CITY OF ALBUQUERQUE

**Re: Old Dominion Freight Line,
330 Airport Rd NW
Request for 30-day Temporary C.O. –Accepted
Engineer's Stamp dated: 3-27-13, (K10D008A)
Certification dated: 10-16-13**

Sheet Name:  
GRADING AND DRAINAGE PLAN

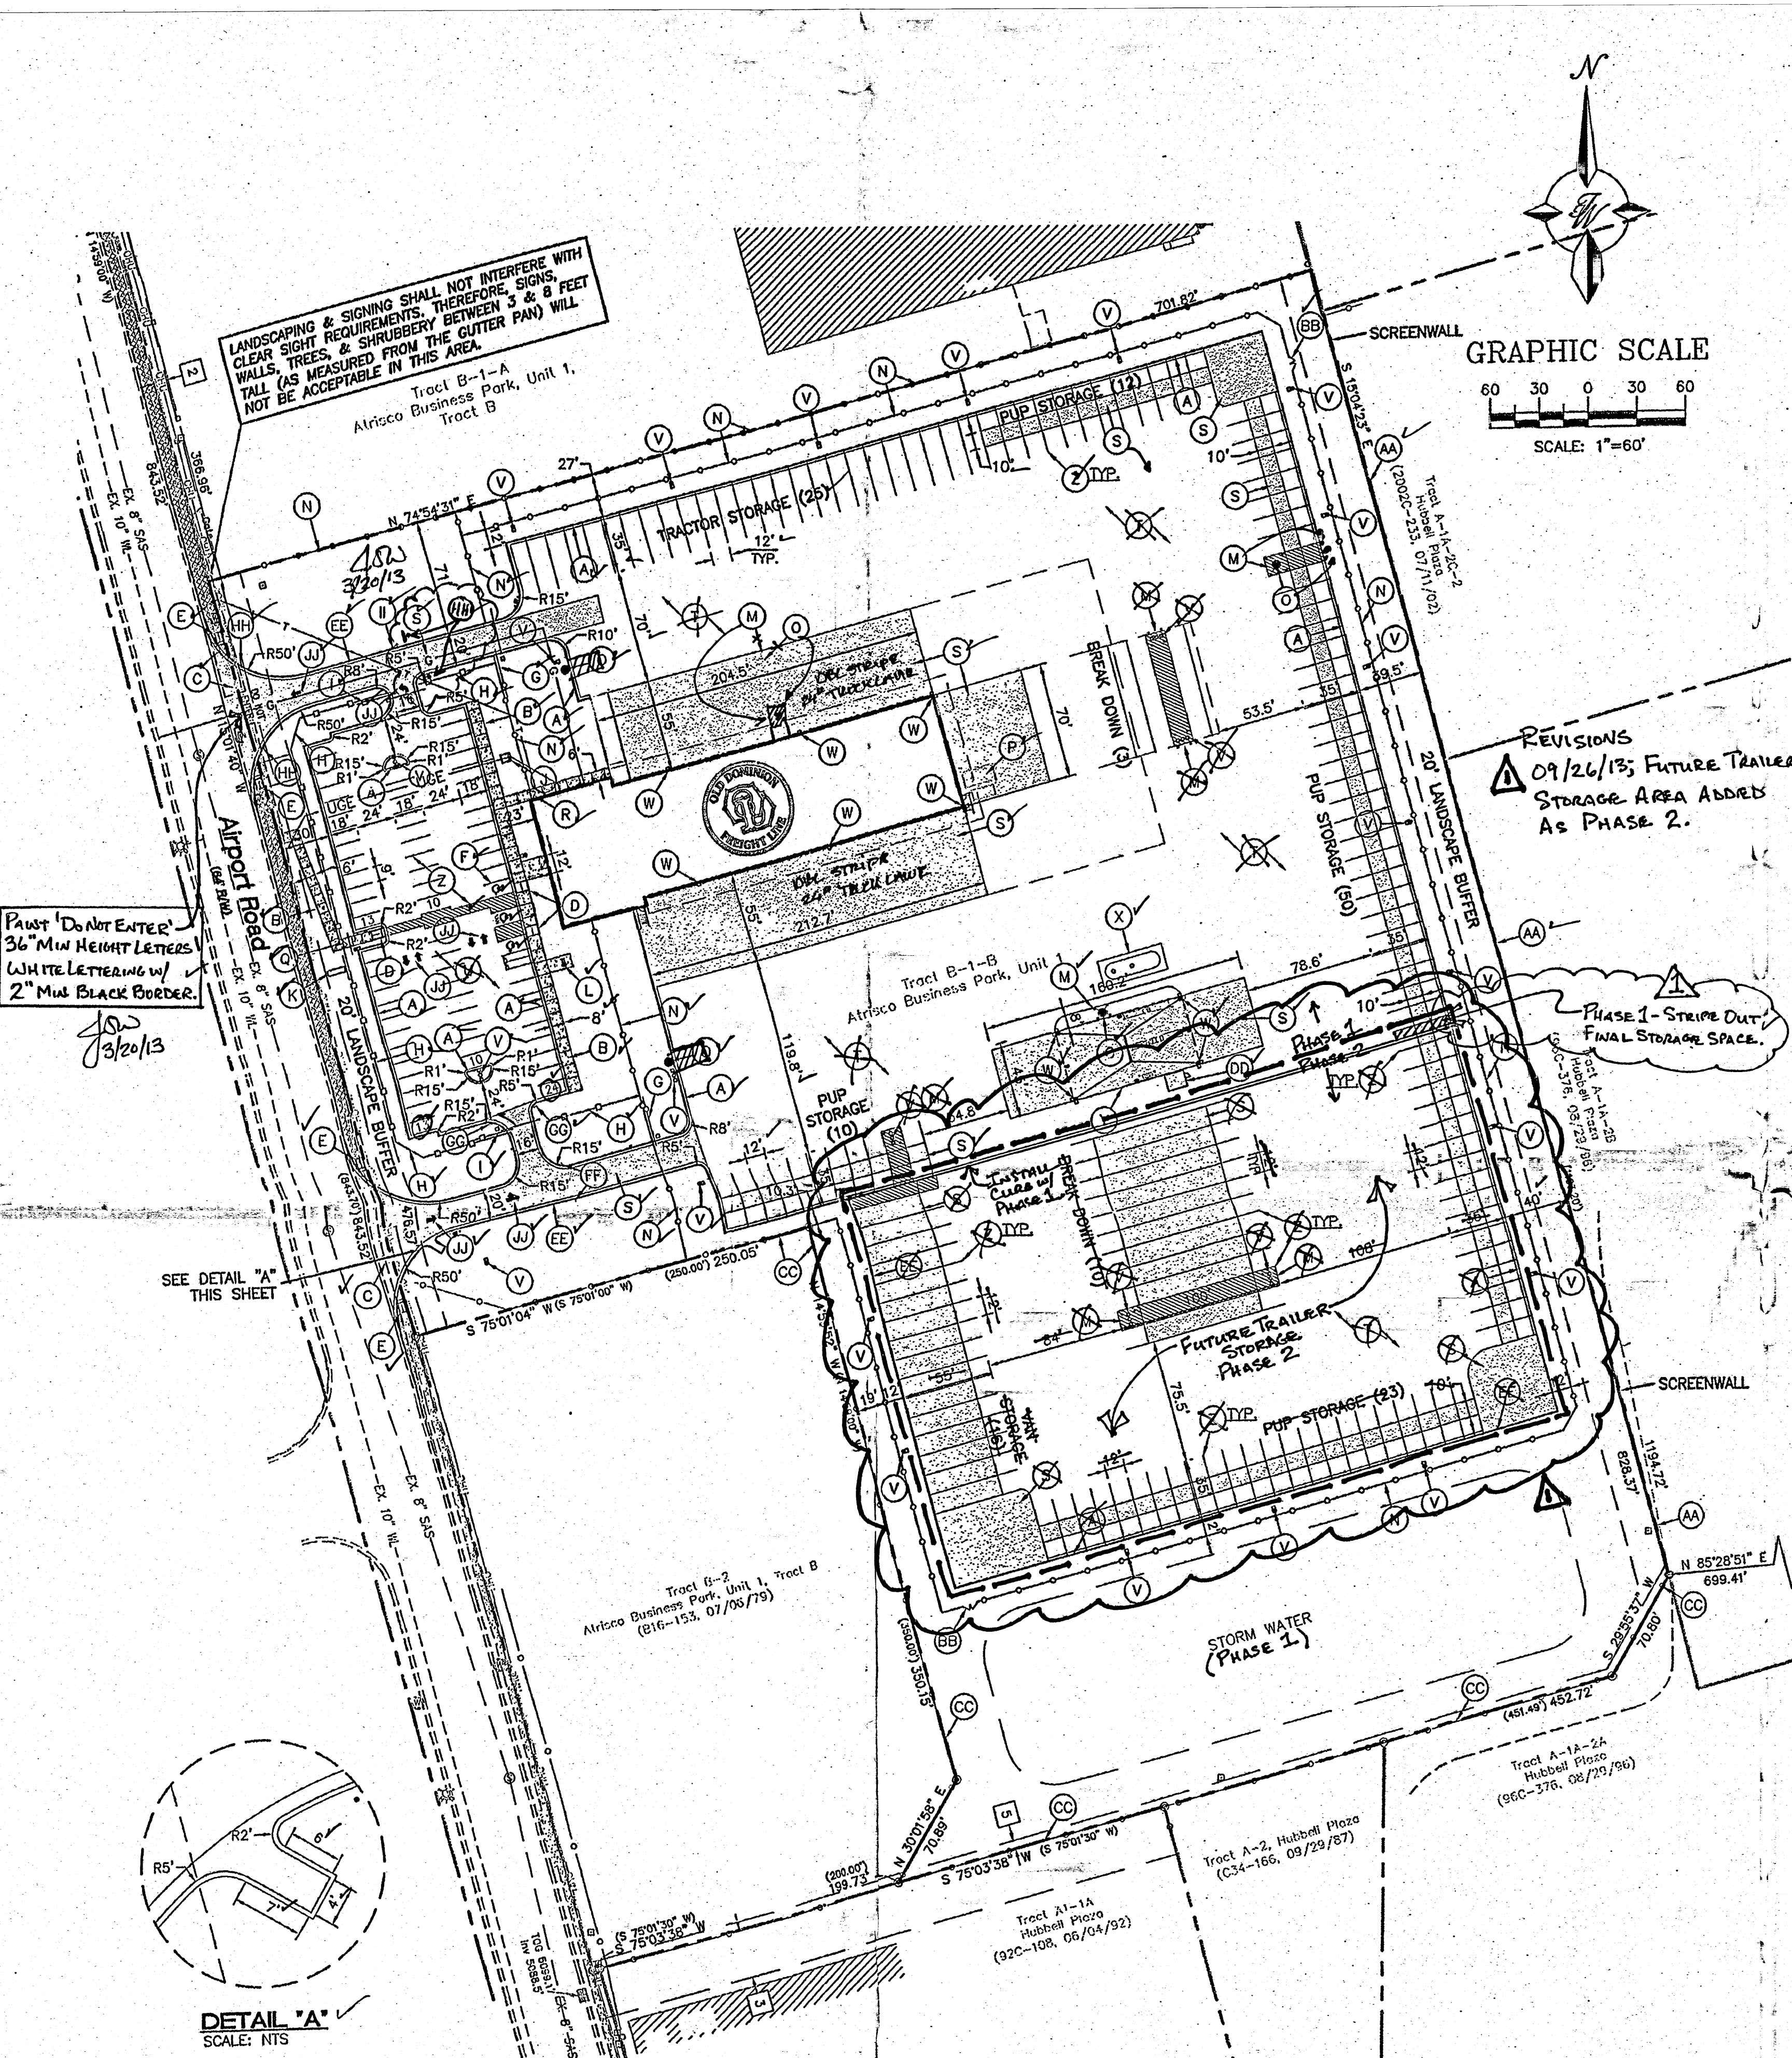
When submitting for Permanent Certificate of Occupancy provide calculations that show the swale along the eastern property line has capacity since flows were diverted to this swale.
